From: Martyn White
Sent: 05 January 2012 10:31
To: Planning.Responses
Cc: Katherine Rawlins
Subject: AW/262/11
Application Number: AW/262/11

Address: 9 Kingsway, Bognor Regis

Description: New driveway, hardstanding and landscaping

GROUND FLOOR PLAN

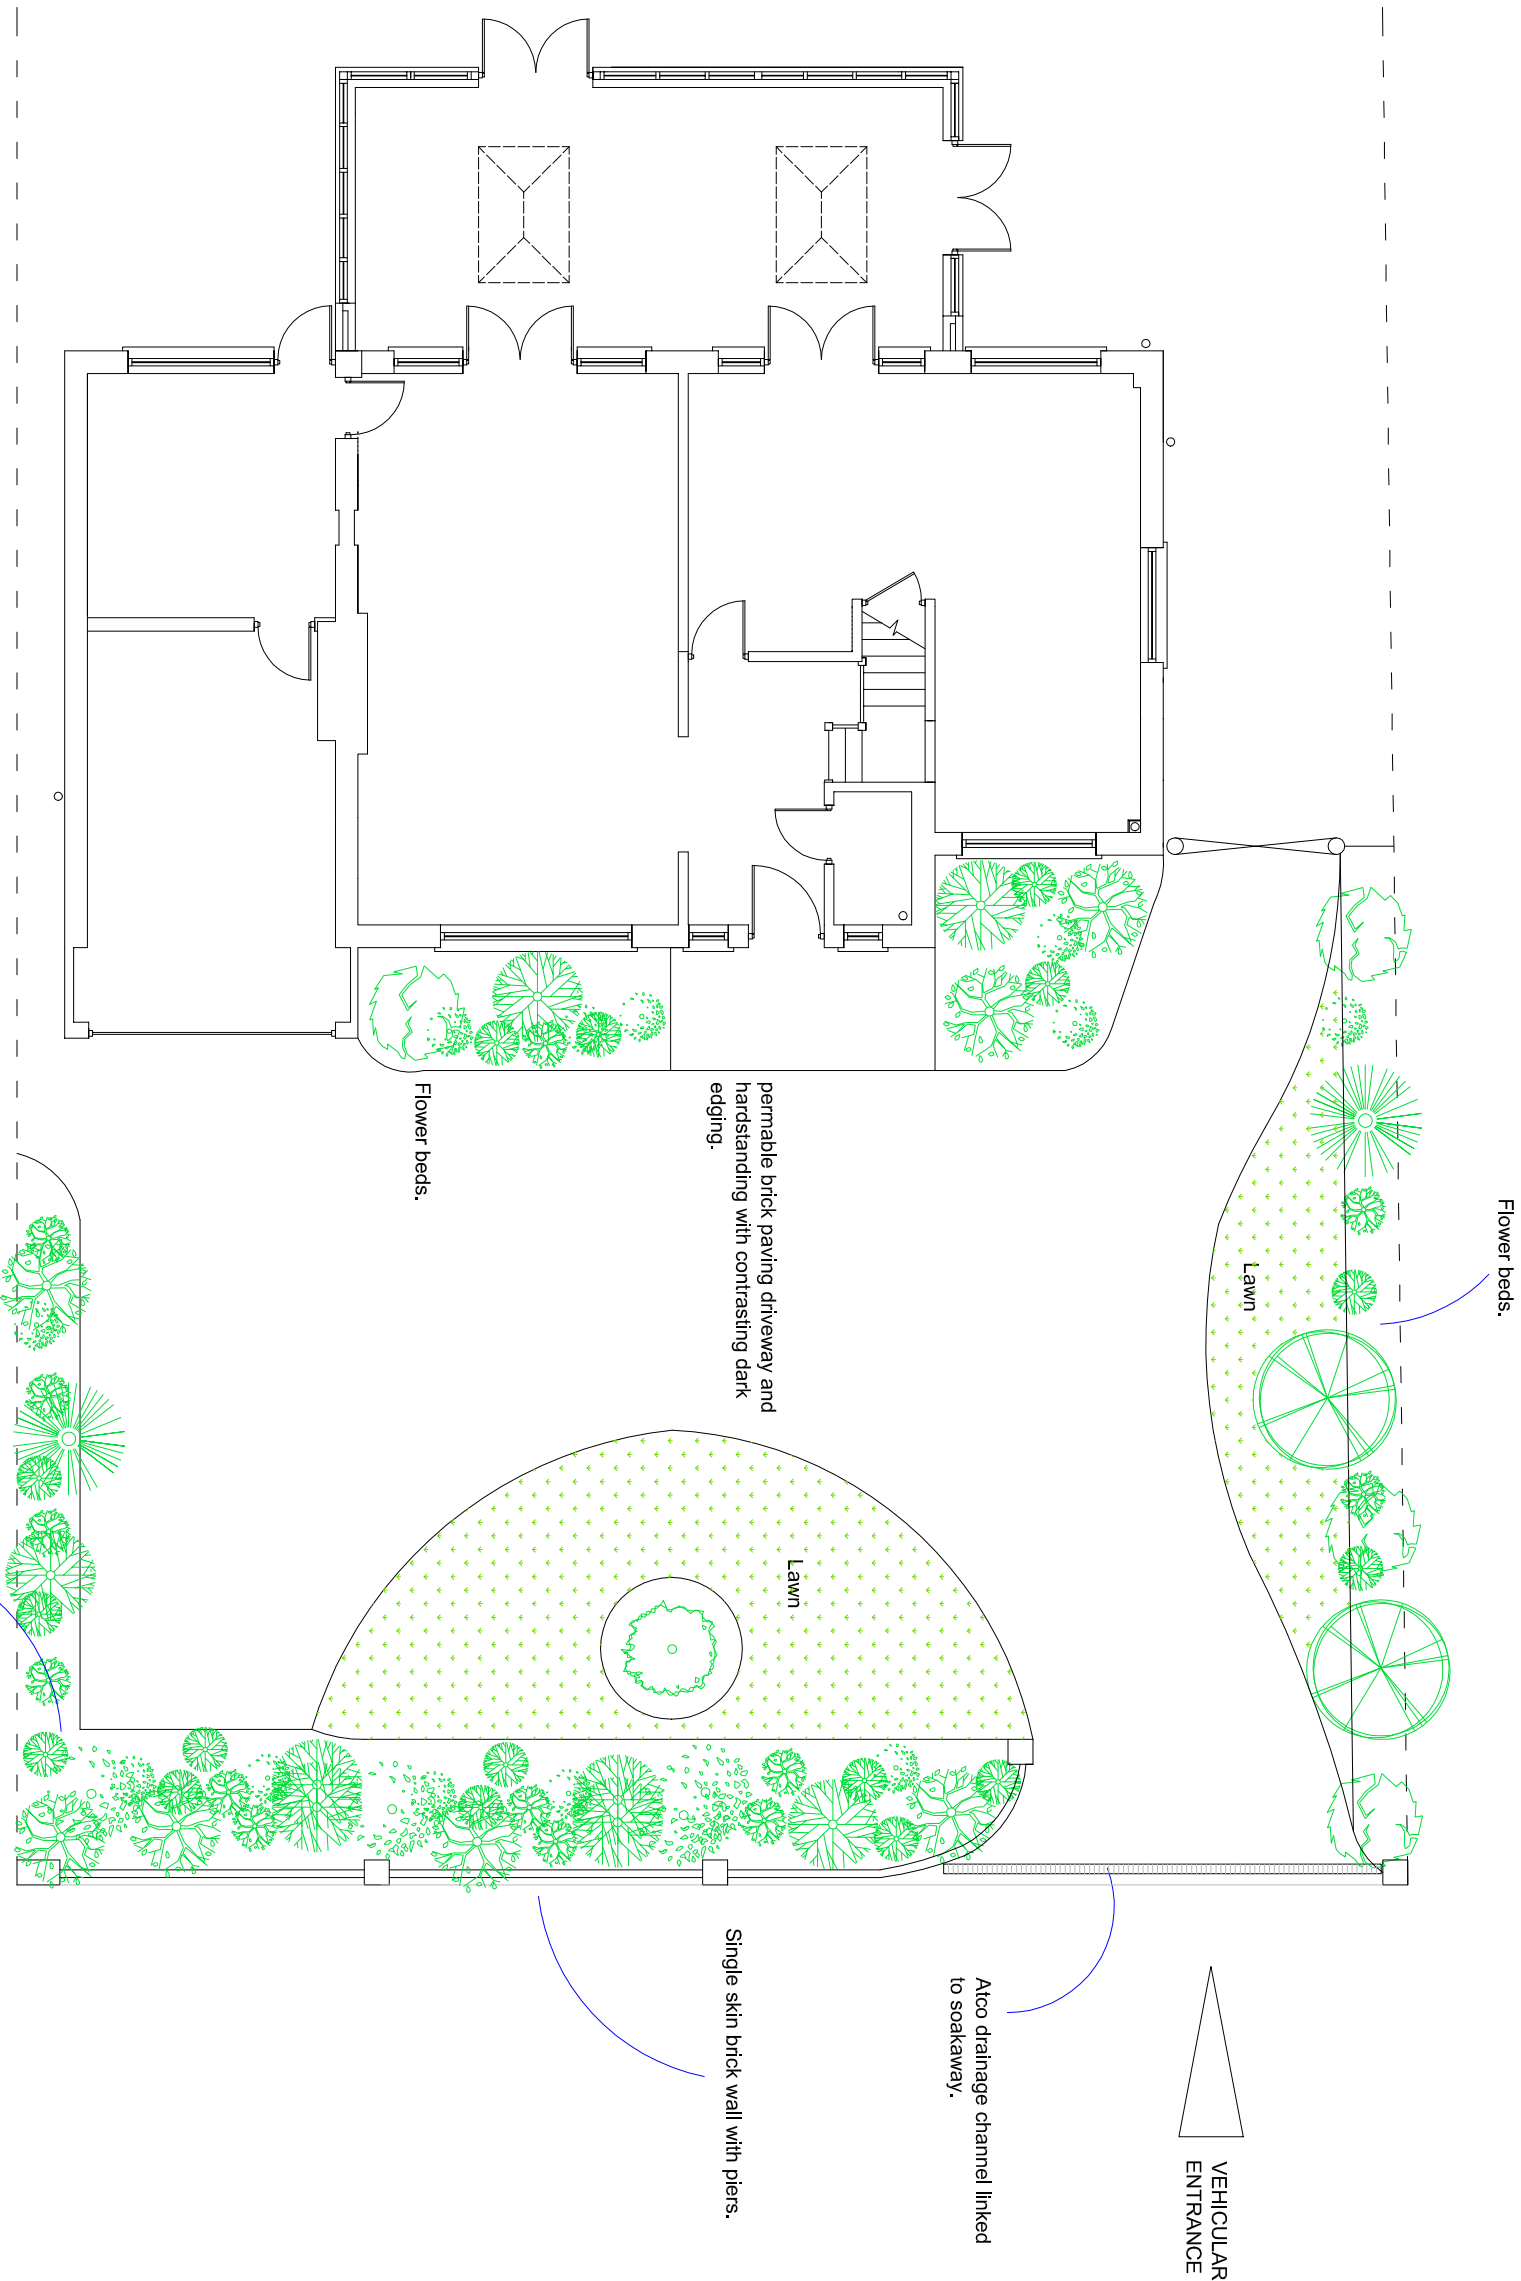
The applicant has made an attempt to increase the amount of soft landscaping whilst at the same time reducing the amount of hard landscaping. The area of soft landscaping in application AW/155/11 covered an area of approximately 55 square metres, whilst in the current proposal it is approximately 90 square metres. This is an increase of some 35 square metres, which equates to increase from 24% coverage to 40%.

Whilst this increase in soft landscaping is supported, the proposal should be accompanied by a landscaping and planting scheme so that it helps to minimise its impact on the area. In addition it would also increase the amount of vegetation present in the locality.

Therefore, if this application is to be approved, information regarding the provision of a landscaping/planting scheme should be required by condition so that its impact can be minimised.
